From: Jeff Nordberg <jeffreynordberg@gmail.com>
Sent: Wednesday, June 2, 2021 4:34 PM
To: Lauren Anderson
Subject: SUB21-002

I have concerns on the application for short plat approval referenced in the subject line.

Figure 21. Tree table.

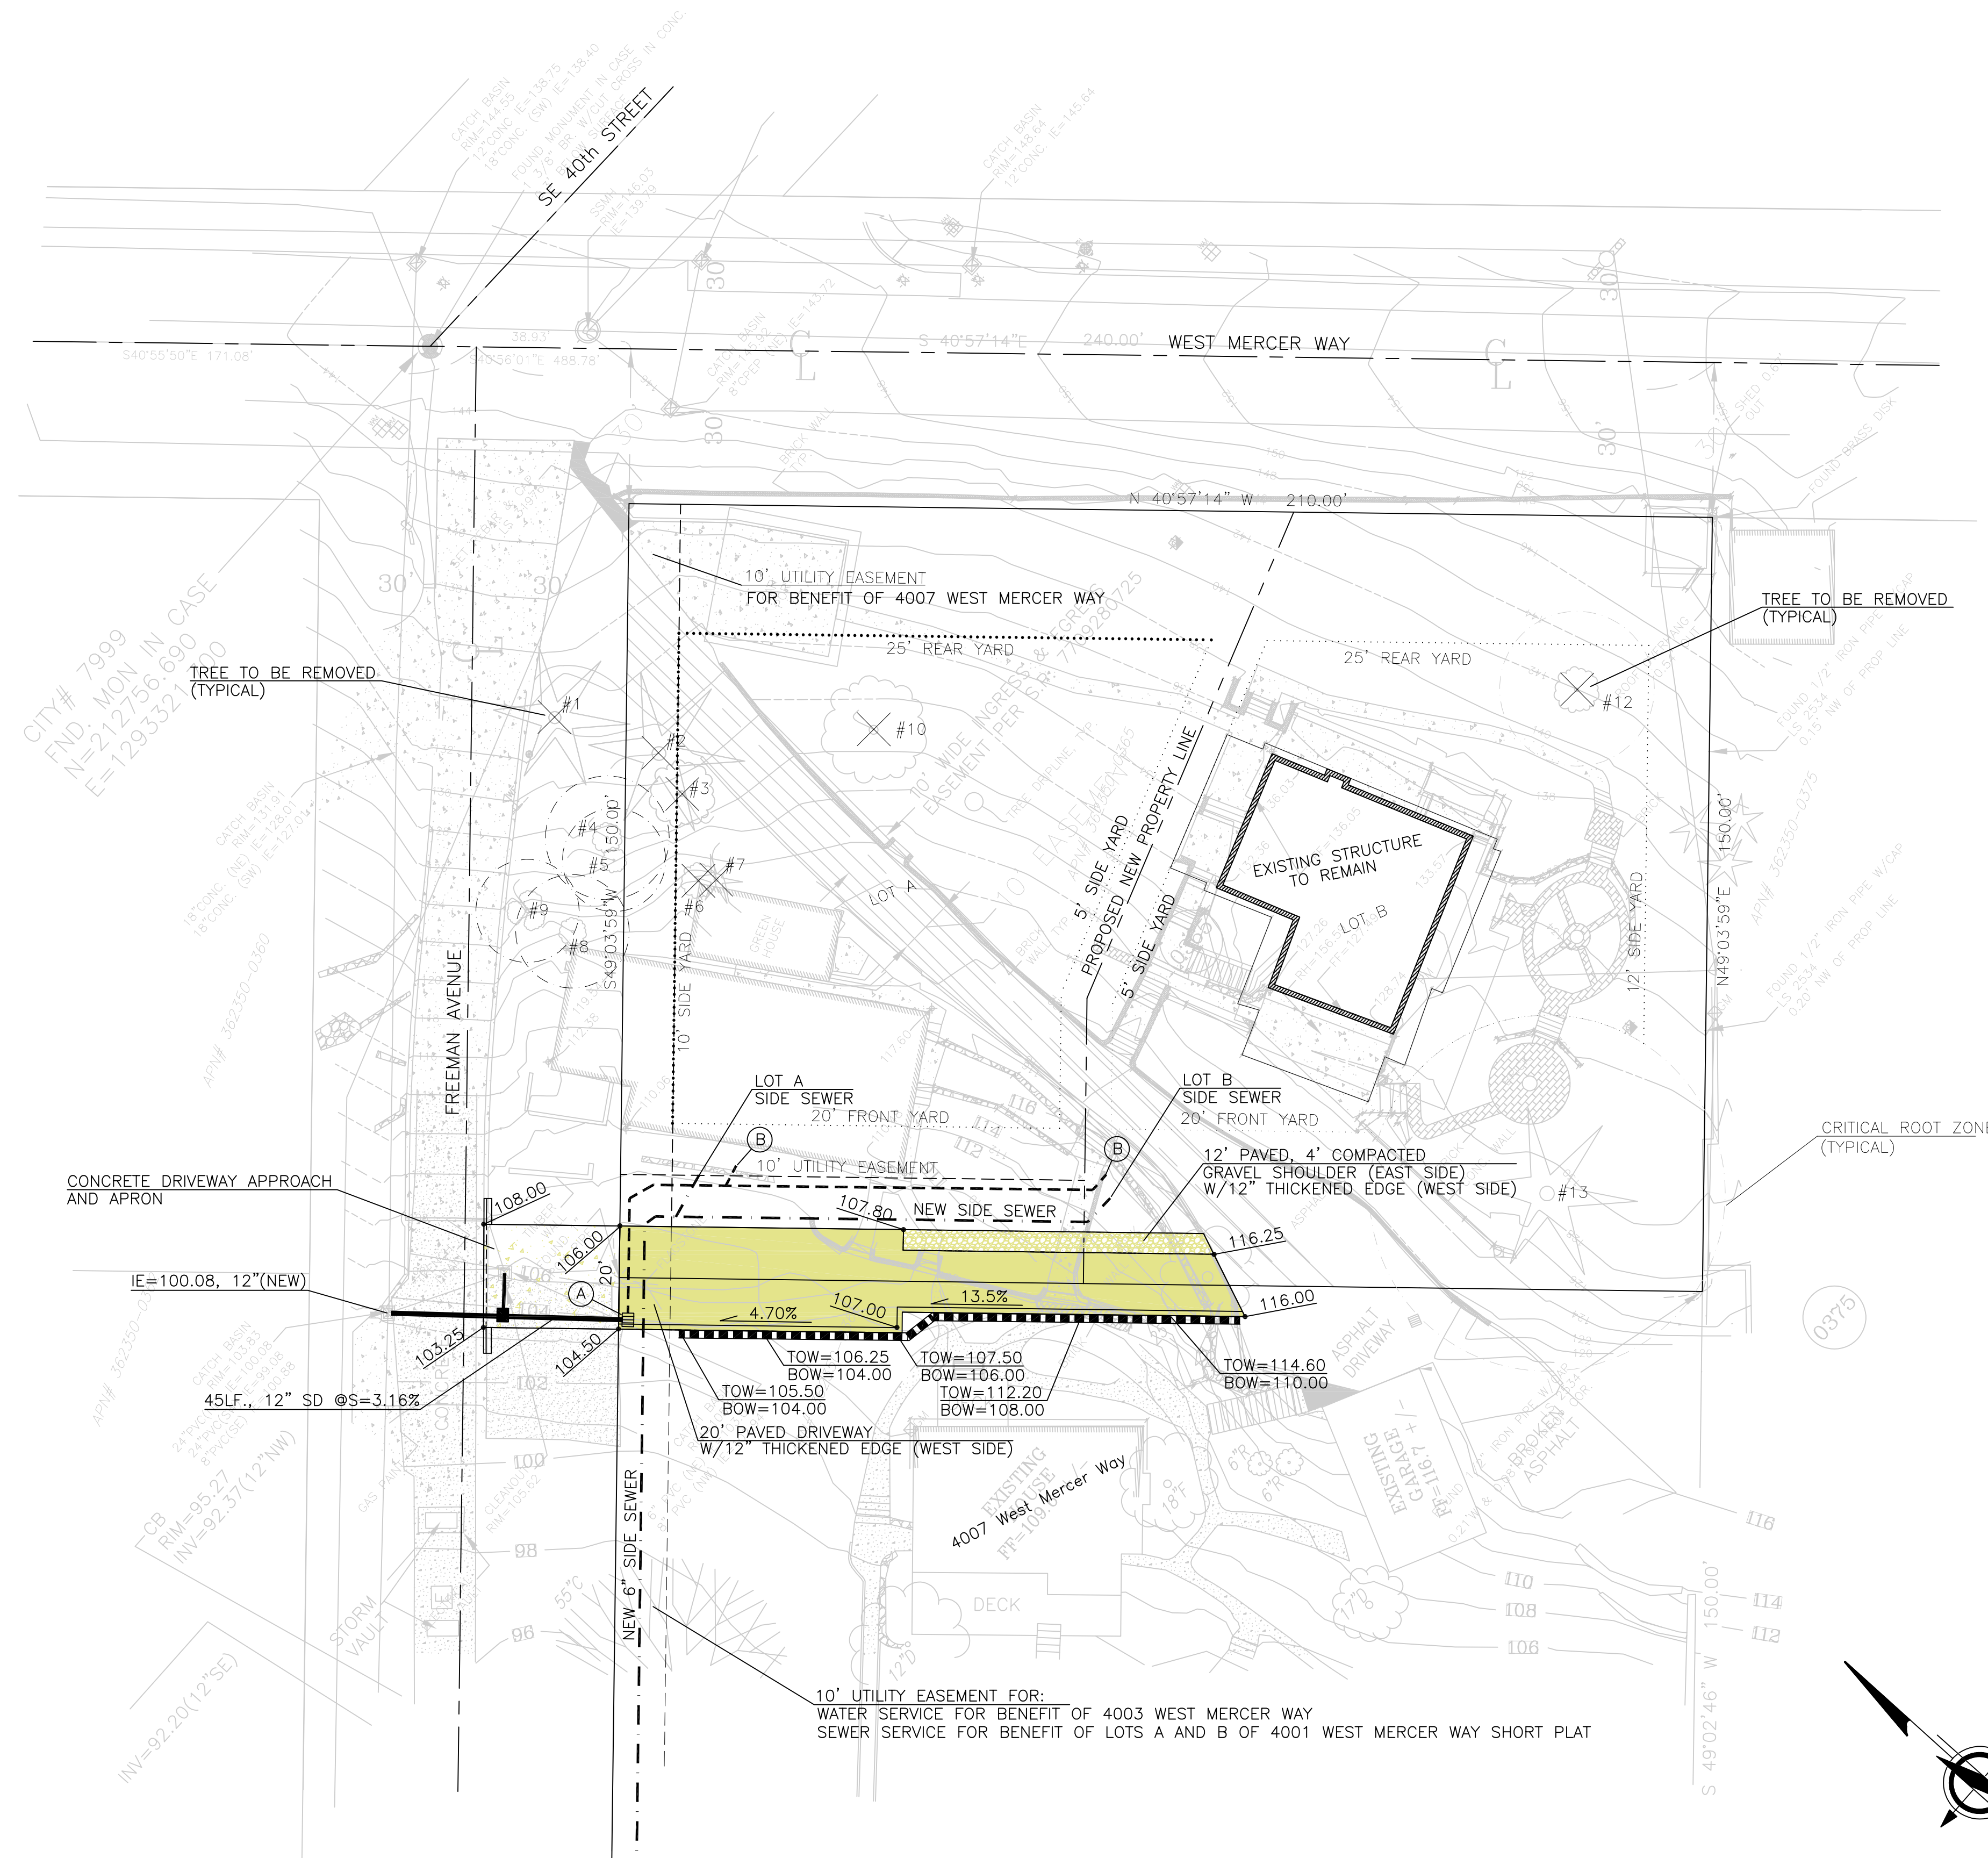
1. Tree impact - For the care of remaining or replaced trees, request a care plan defined for height and growth. For any new trees planned, have details on type, size, planned height defined and reviewed.

2. Hedge/walking considerations on West Mercer Way. ('#11 massive hedge' per 7a-4001) Current hedge leaves no safe walking on the shoulder. Hedge should be trimmed for clearance or removed.
